**KIRKLEES METROPOLITAN COUNCIL
INVESTMENT & REGENERATION SERVICE**

DELEGATED DECISION TO DETERMINE PLANNING APPLICATIONS

Reference No: 2020/62/91952/W
Site Address: 38, Heights Drive, Linthwaite, Huddersfield, HD7 5SU
Description: Erection of extension to garage and porch
Recommending Officer: Stuart Howden

DECISION - REFUSED

PROPOSED LINKED  
GARAGE

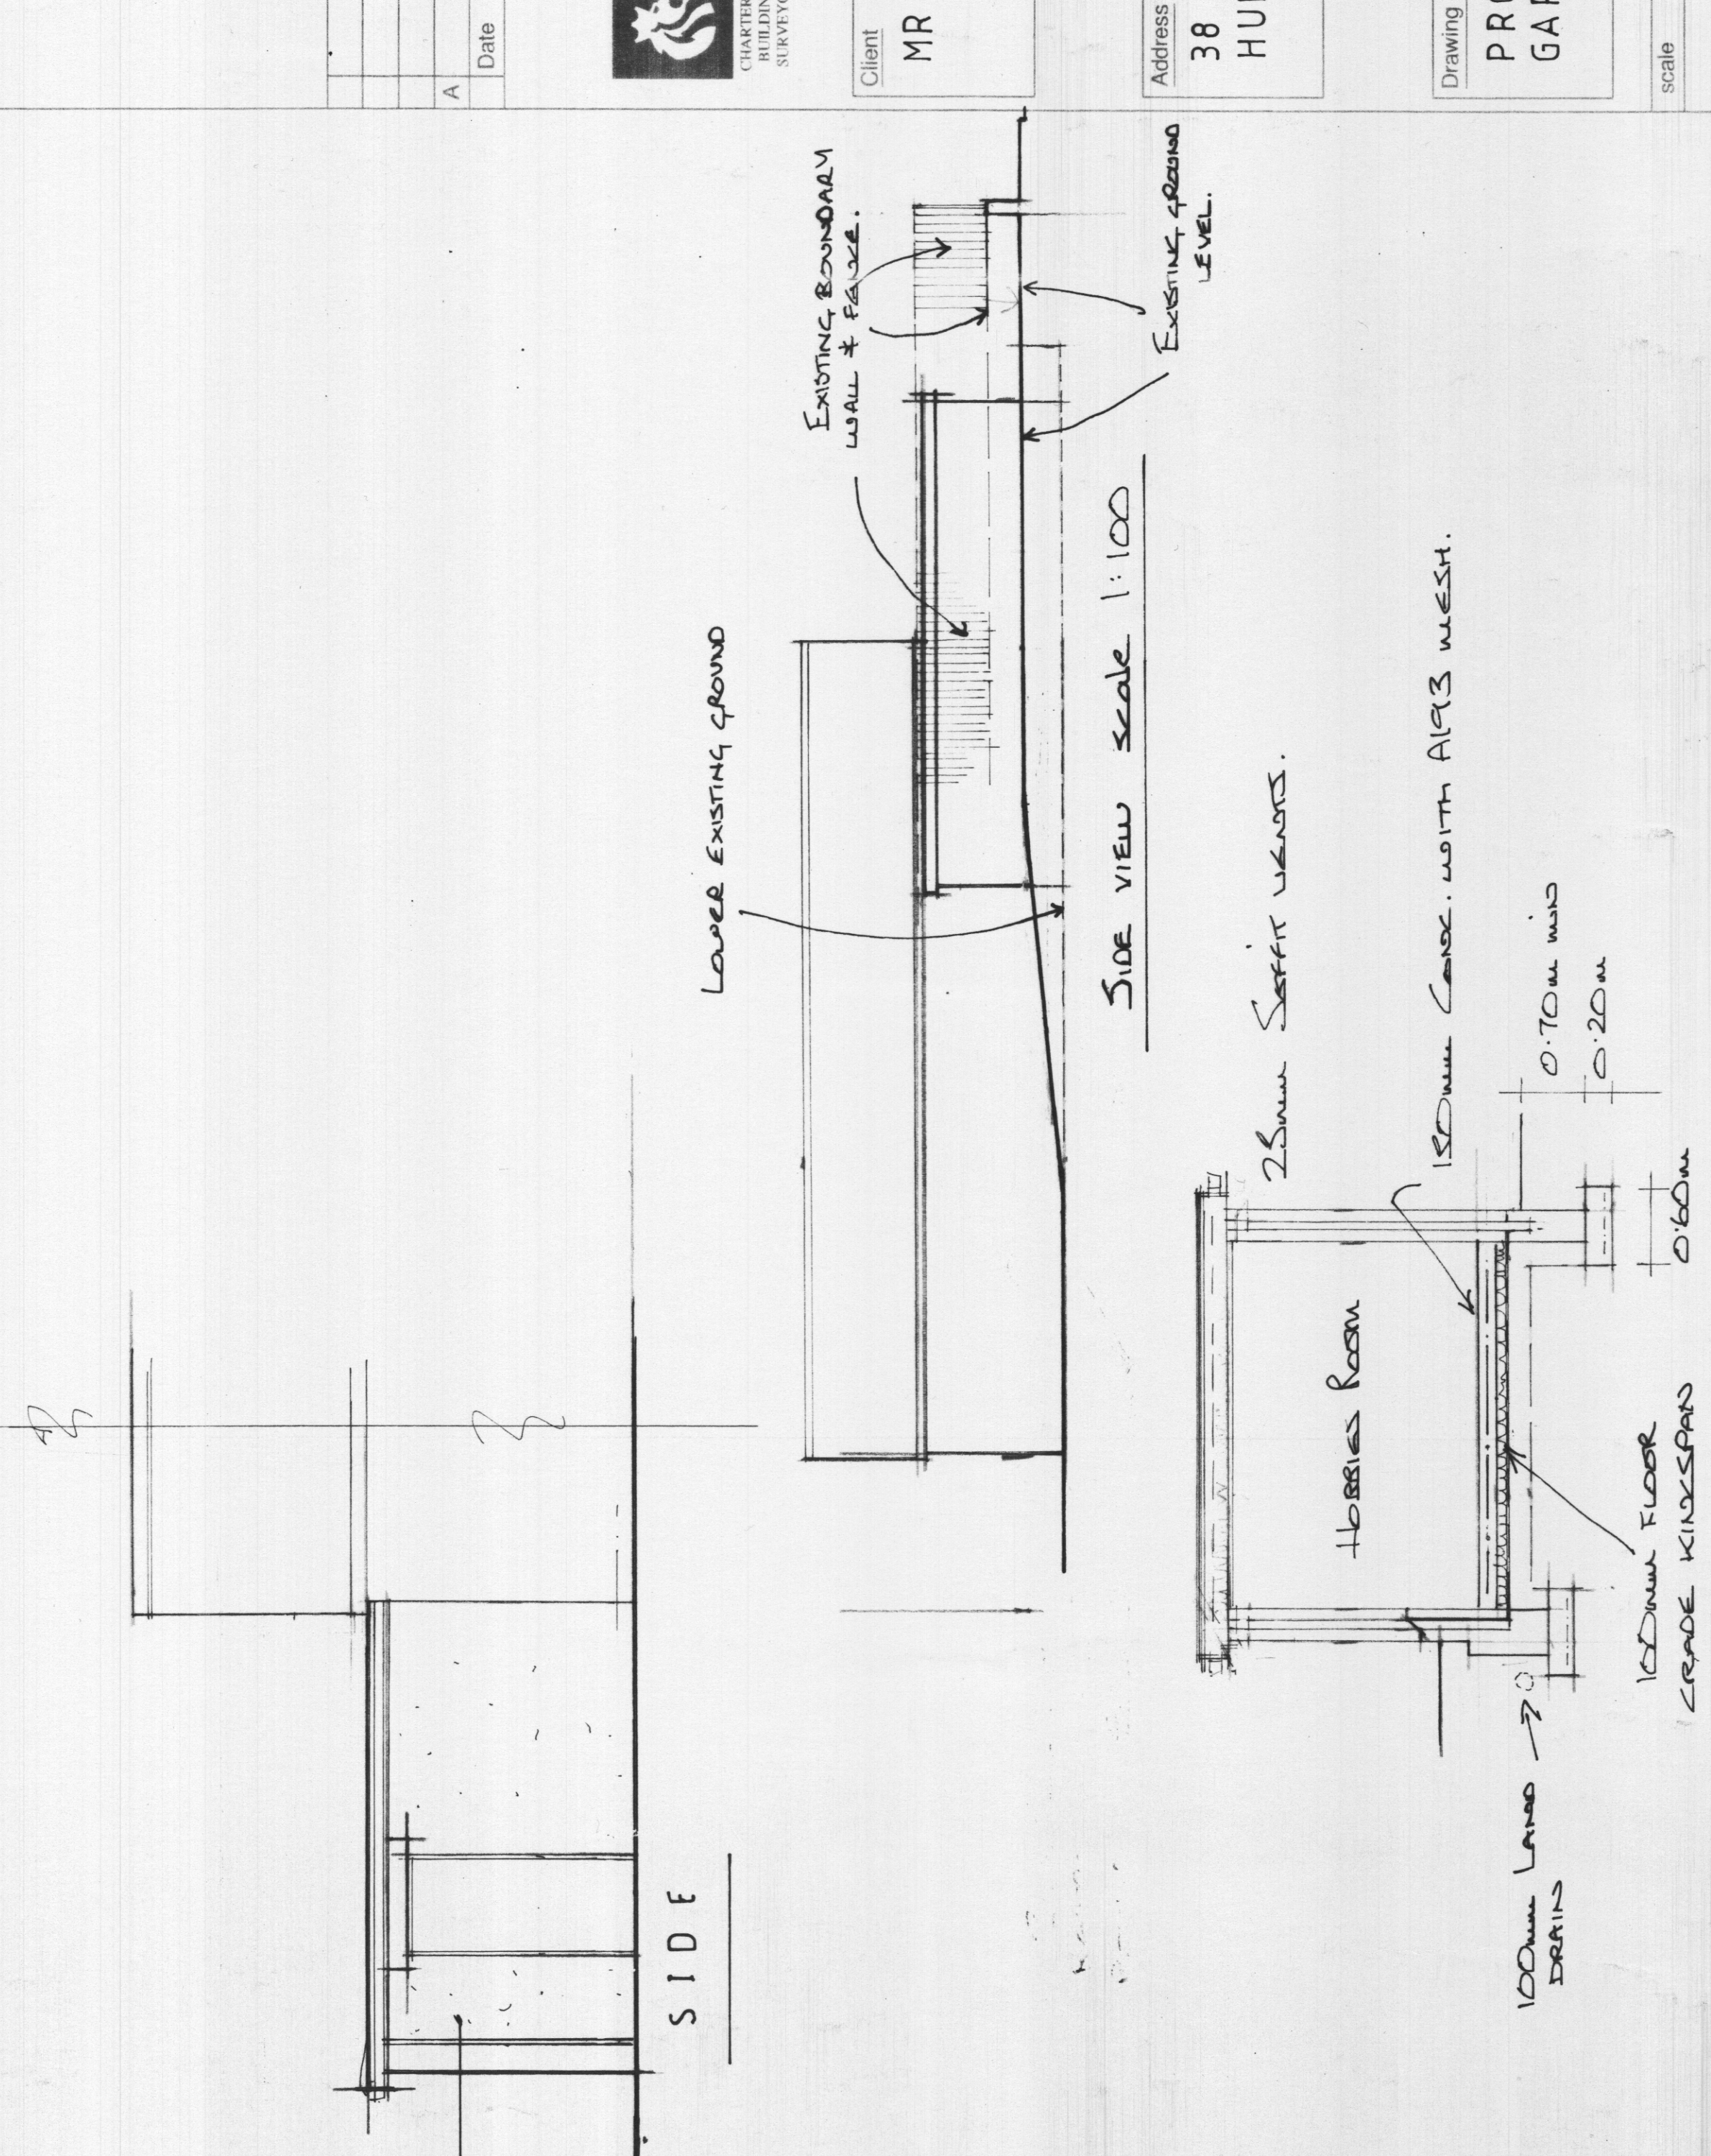
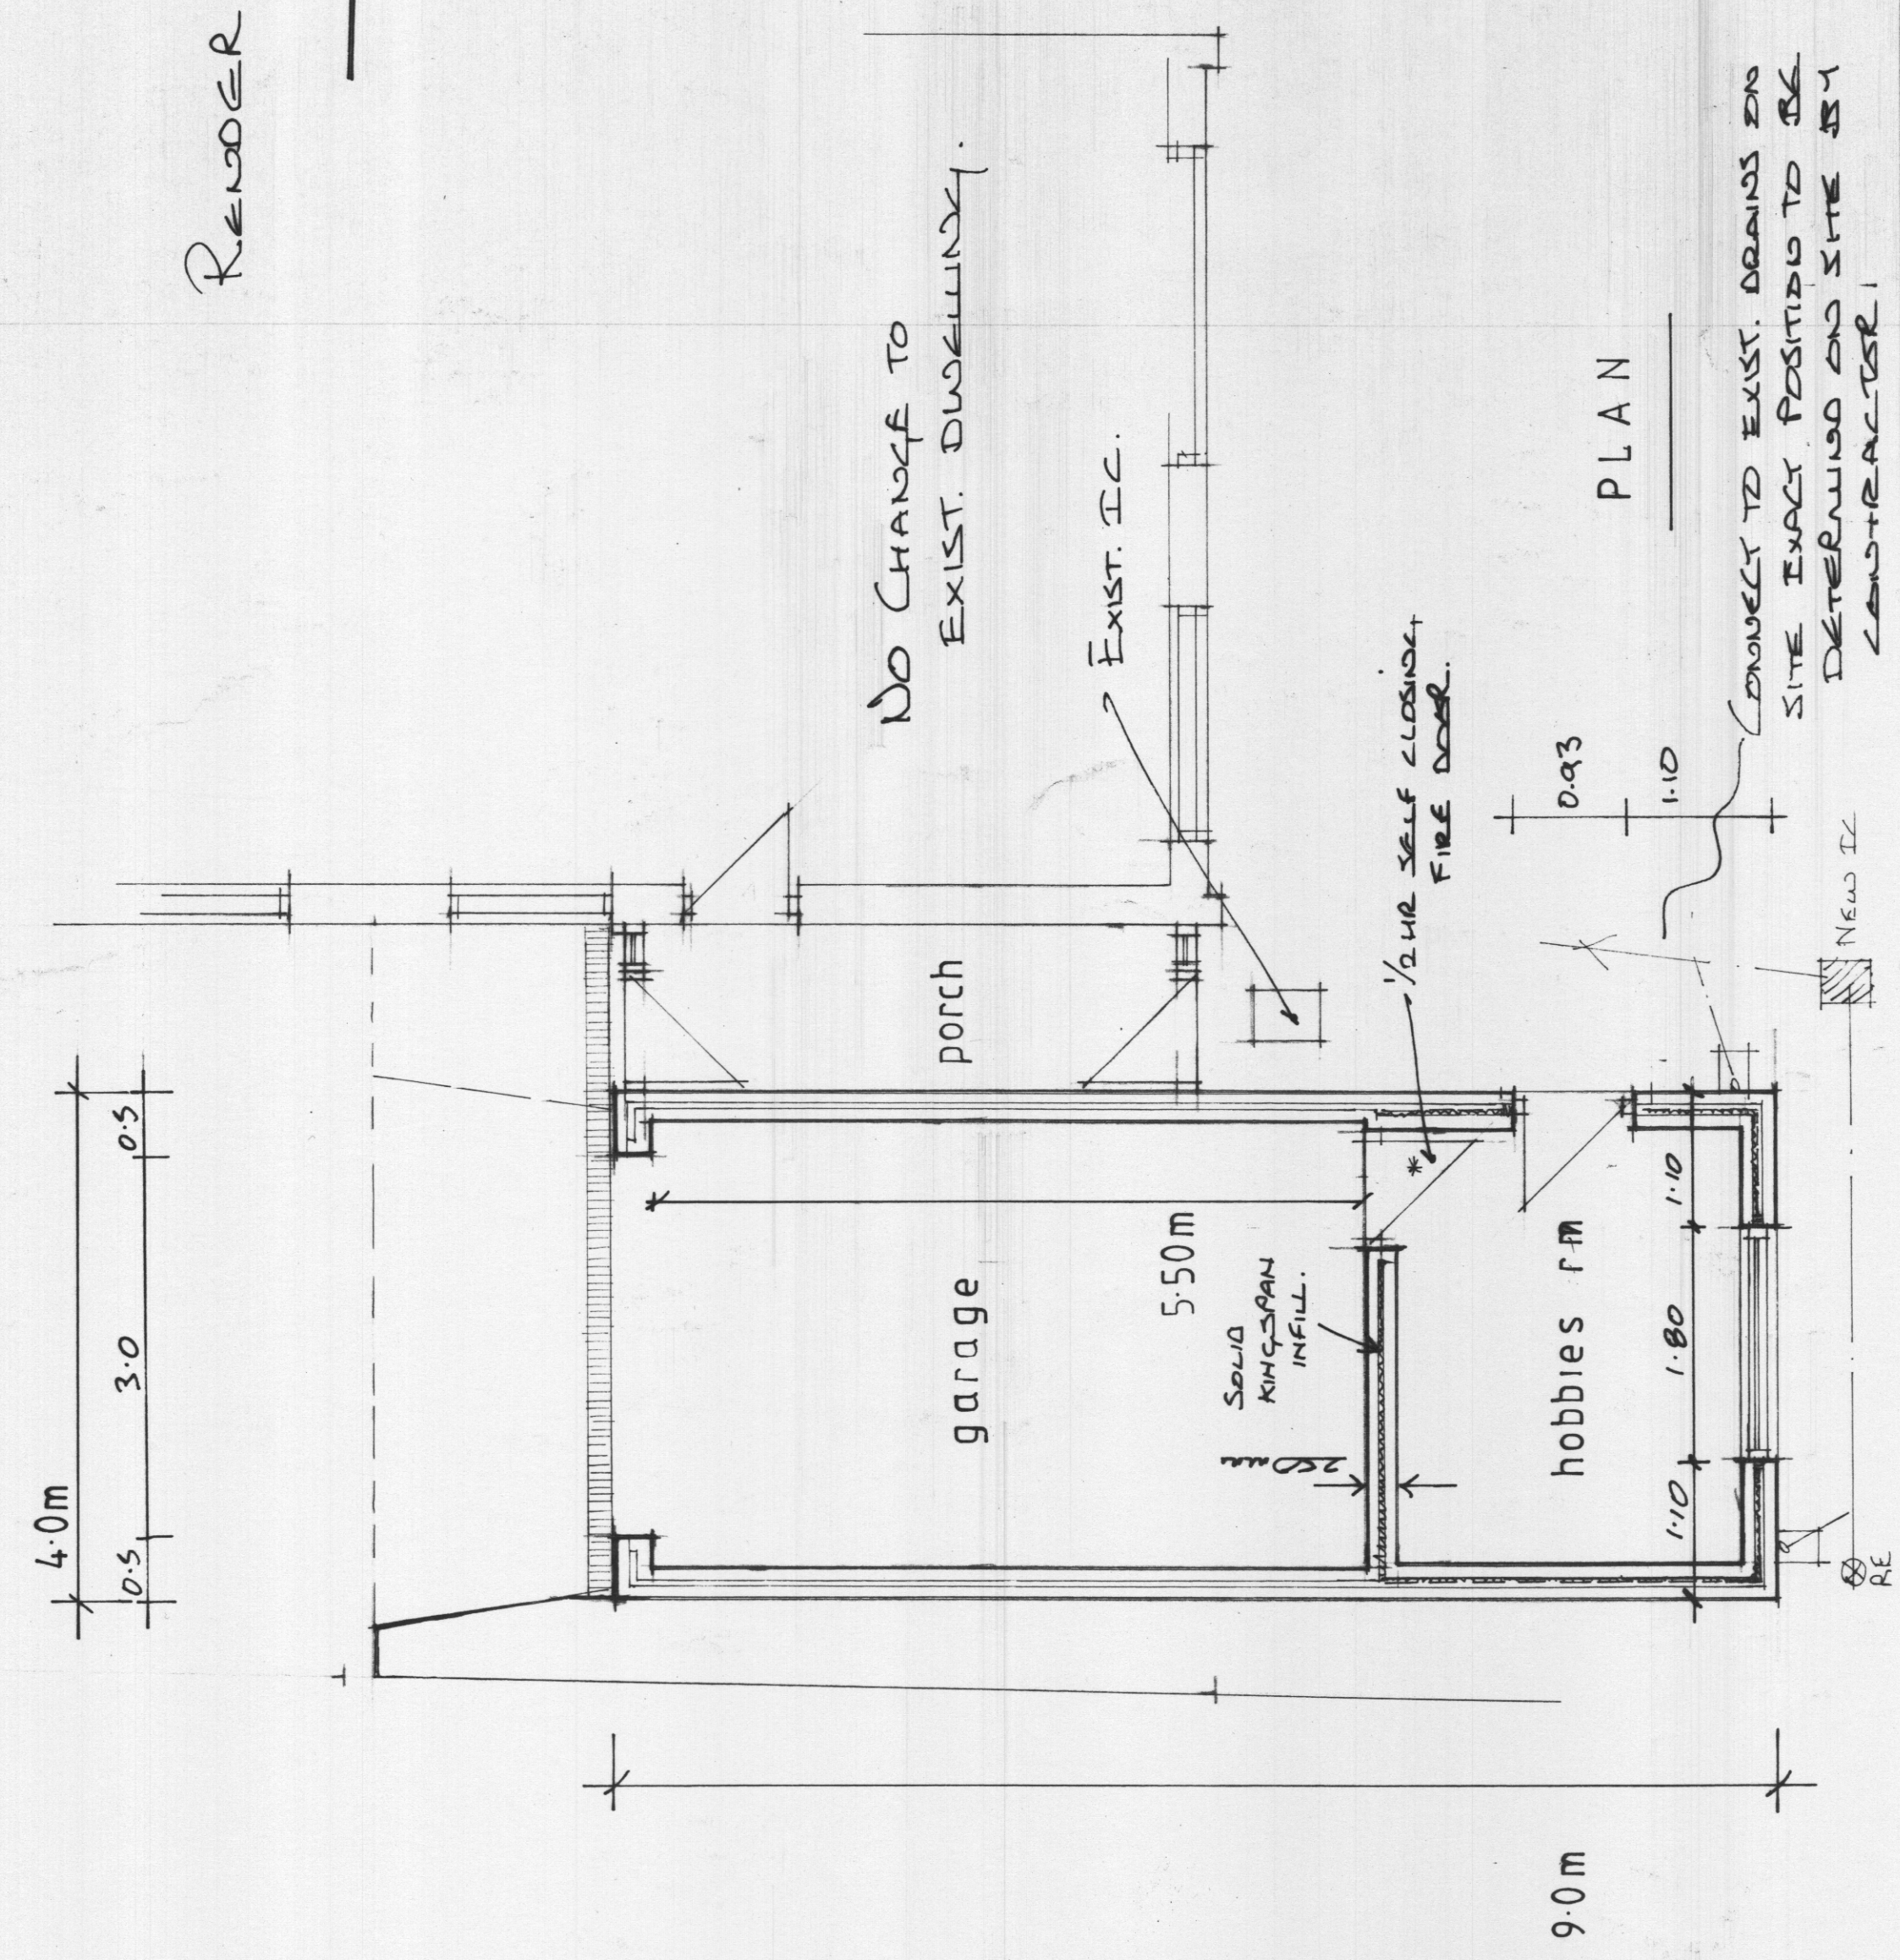
It is considered that the form of the proposed extension would not be in keeping with the existing dwelling. The proposed extension would disregard the simple linear form of the existing dwelling, given that it would be an 'L-shaped' extension with a relatively large footprint, protruding beyond the front and side walls of the host building. The flat roof of the extension would also be at odds with the host building which has a pitched roof. In addition to this, it is considered that the use of render for the walls of the extension would poorly relate to the stone used on the existing dwelling, and that the mass area of blank wall running adjacent to the highway to the west of the site would be an unattractive design feature.

Further to the above, as the proposed extension would protrude outwards beyond the front wall and south side wall of the existing dwelling, and relatively close to the highway boundary, both to the west and south, it would appear as a conspicuous feature from within the streetscene that would compete in prominence with the existing dwelling. The applicant's agent has noted that the fencing on the boundaries of the site would help screen the extension, and whilst the fencing would contribute in partially screening views of the extension, it is considered that it would still be visible from the public domain. Regardless of the fencing, it is considered that the proposed extension would have an incongruous and contrived appearance and would constitute an unsympathetic addition to the host building, thereby it would not constitute good design.

Given the above, it is considered that by virtue of its prominent siting, unsympathetic form and appearance, and scale, the proposed single storey extension would appear as an incongruous and discordant feature to both the host dwelling and wider streetscene, thereby causing detrimental harm to the character, quality and appearance of the area. The proposal would therefore be contrary to Policy LP24 (A) and (C) of the Kirklees Local Plan and Government guidance contained within Chapter 12 of the National Planning Policy Framework.

The proposal would not result in the loss of any parking spaces on the site. The internal dimension of the proposed garage are not of sufficient size to accommodate a vehicle in line with current guidance (recommended 3m x 6m when measured internally in the Kirklees Highways Design SPD 2019) therefore this feature cannot be said to be increasing the parking provision on site.
